From: Grant, David
Sent: 01 February 2022 12:23
To: _planningadvice
Subject: FW: Spalding Rugby Club - H16-1223-21

I write in response to the Drainage Boards comments and list in the corresponding order to their points:

Proposed Block Plan
Scale 1:500

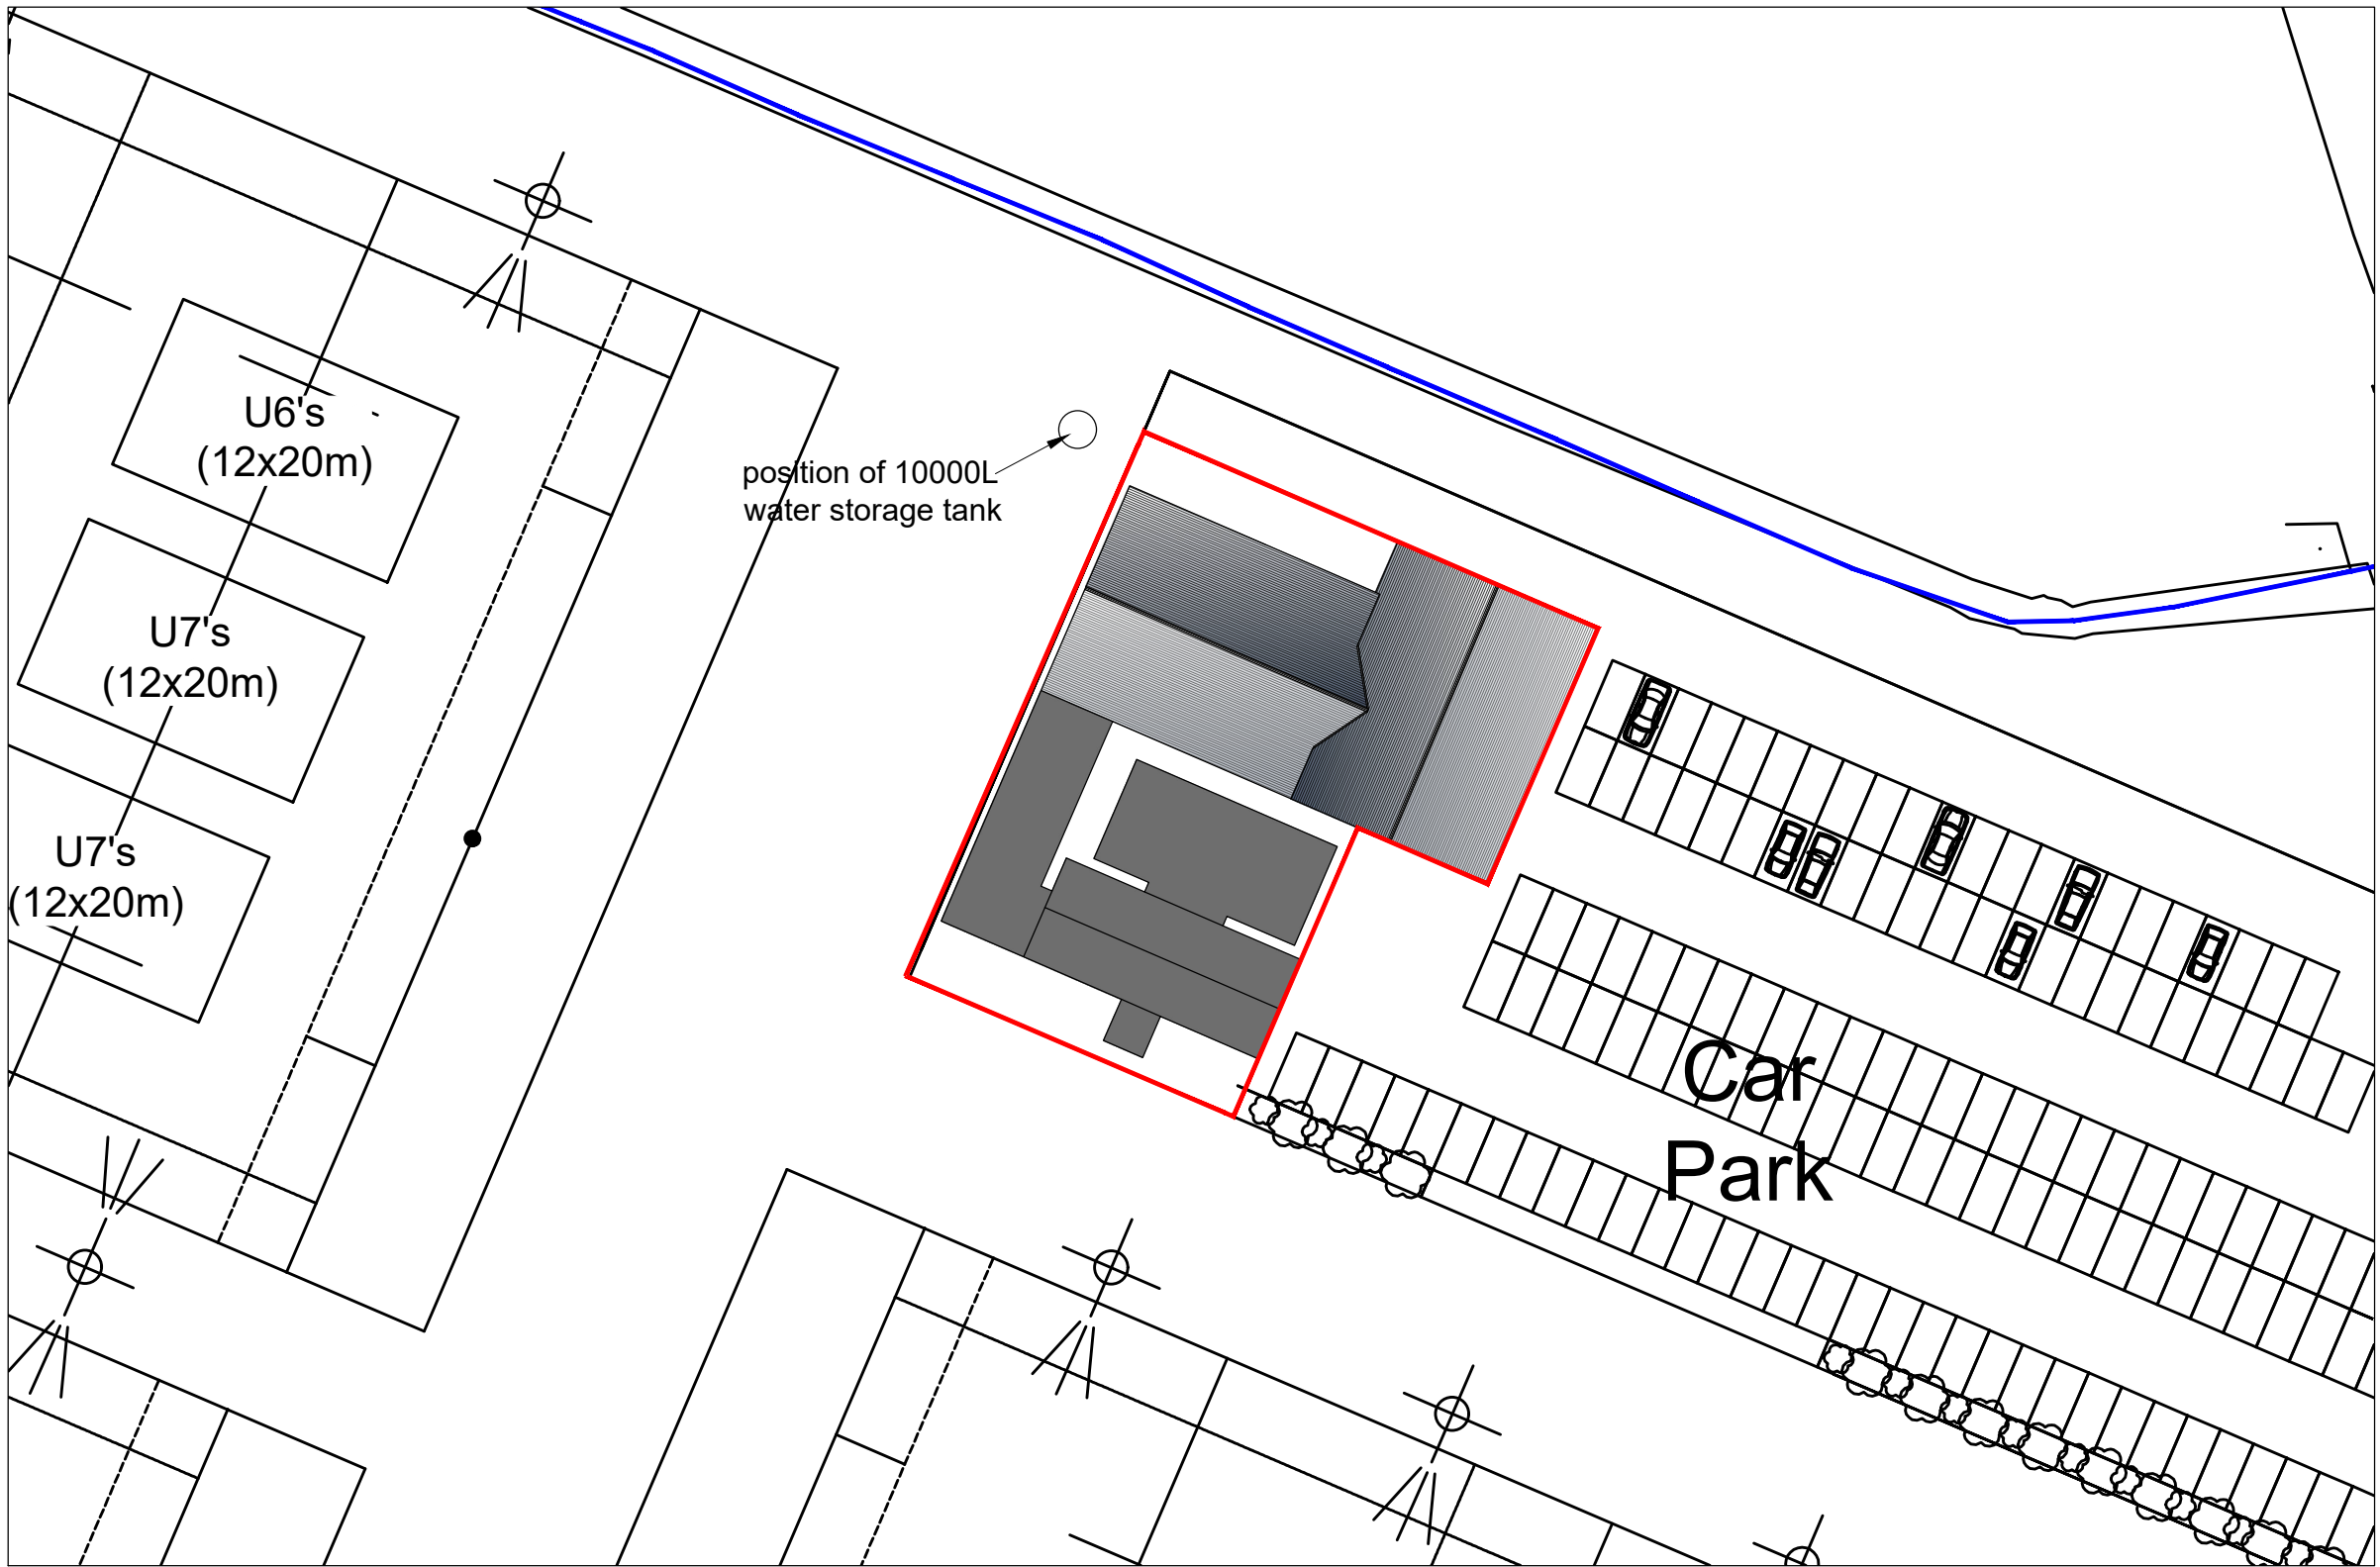
- Agreed that if surface water discharge is proposed to a water course we will obtain the necessary permissions.
- The size of the tank proposed was based on a very basic calculation of roof area x drainage coefficient x annual rainfall which gives a required tank size of just under 6500litres, well below the 10000litre tank shown. This allows for a much greater volume than that calculated plus the calculation does not take in to account the vast quantity of water used to water the pitches therefore we can see no problem with the size specified. If the tank does, in the unlikely scenario, ever overflow we can ensure that there is an overflow pipe that will take the water either to a soakaway or to a water course, again seeking the necessary permissions at the time.

- Agree that consent will be needed if we propose to go within 9m of the Clowacre Drain, however we do not intend to do this so an unnecessary comment.
- As above, no plans to alter the watercourse so an unnecessary comment.
- As above, no plans to alter the watercourse so an unnecessary comment.

- We would be installing new soakaways for the surface water discharge from the changing rooms, the existing soakaways have been in place for some time now and would most likely not suitable for the new use, therefore in order to mitigate any future issue we will install a new system all of which will be designed accordingly based on the roof area and the results from a permeability test carried out at the necessary stage.

- The package treatment plant is already installed and the size was calculated for this scenario when installed, therefore it has ample capacity plus the soakaway installed is suitable and all signed off by Building Control. It will not be necessary to need to discharge the treated water from this in to a water course in the future.
